WEST SUSSEX COUNTY COUNCIL CONSULTATION

TO:	Arun District Council FAO:
FROM:	WSCC - Highways Authority
DATE:	13 May 2019
LOCATION:	4 Broadmark Lane, Littlehampton, BN16 2NE
SUBJECT:	R/34/19/PL Change of use of currently vacant former A1 (Shops) ground floor premises to a mixed A3/A5 (Restaurants & Cafe & Hot Food Takeaway) use, incorporating the erection of a single storey rear extension, replacement shopfront & associated plant & extraction equipment.
DATE OF SITE VISIT:	N/A
RECOMMENDATION:	Advice
S106 CONTRIBUTION TOTAL:	N/A

proposed ground floor general arrangement plan
scale - 1:50 @ A1 / 1:100 @ A3

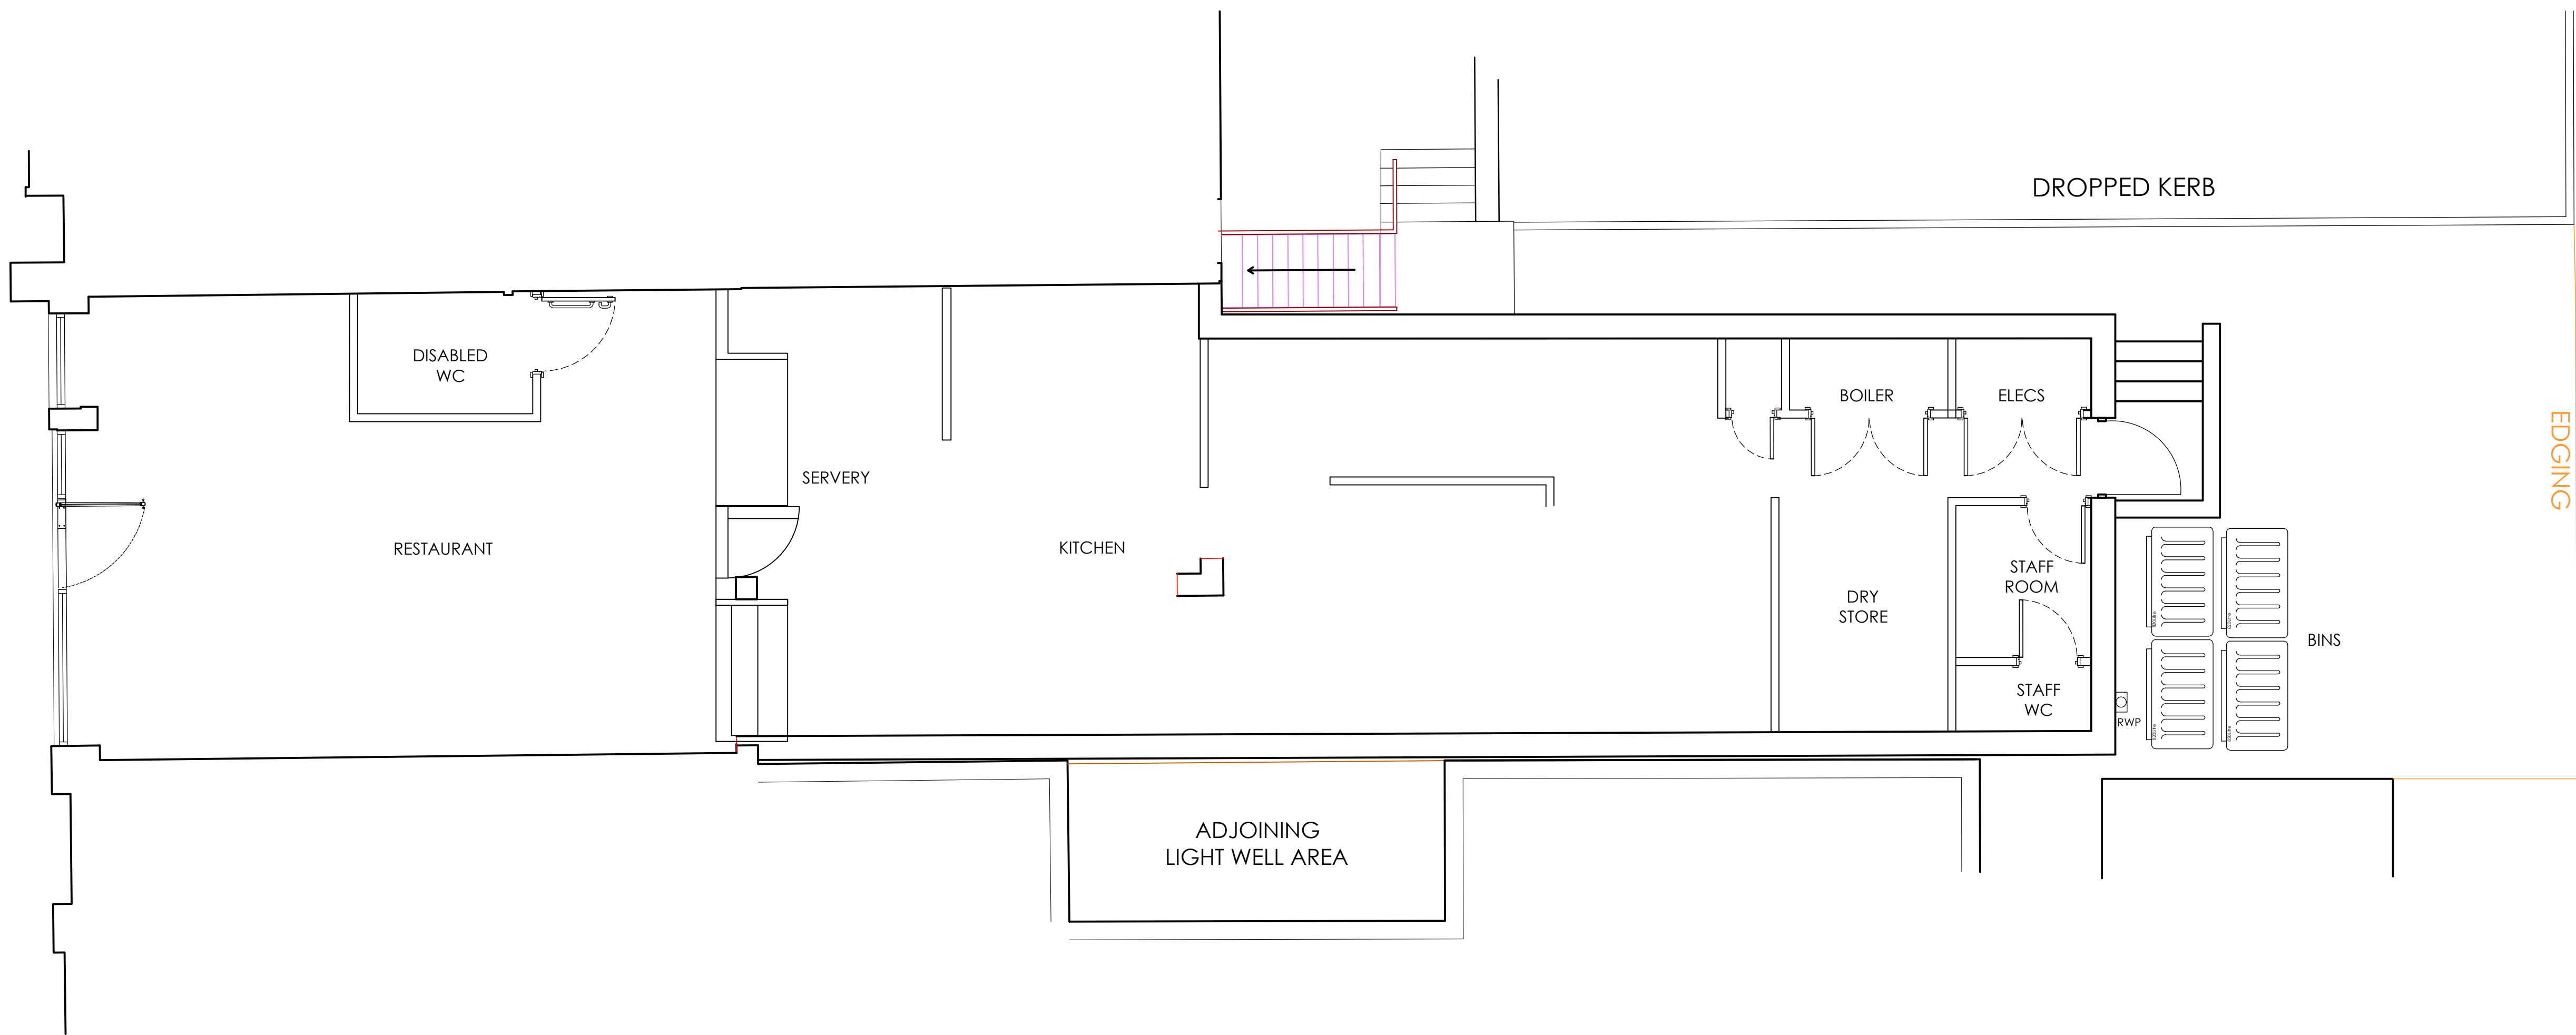
No alterations to the existing access to the rear of the site are proposed. This application proposes a rear extension to the site which will increase the floor area of the proposed shop to provide a kitchen area. Given that no vehicular access currently exists to the site for customers/visitors to the existing shop, this proposal is not anticipated to result in a material intensification of vehicle movements to or from the site.

A parking layout plan has not been provided by the applicant. WSCC mapping indicates that currently at least two vehicles can park to the rear of the site, although it is unclear whether these spaces serve the retail use or residential use above. The proposed extension will affect the existing parking arrangements. Whilst this is not anticipated to result in a highway safety concern, the LPA may wish to consider the potential impact of overspill parking on on-street parking in the vicinity. Nearby roads benefit from junction protection preventing vehicles from parking in locations that would cause a highway safety concern. The site is sustainably located within walking distance of a variety of other local shops and services and bus stops providing access to Worthing, Littlehampton and further afield.
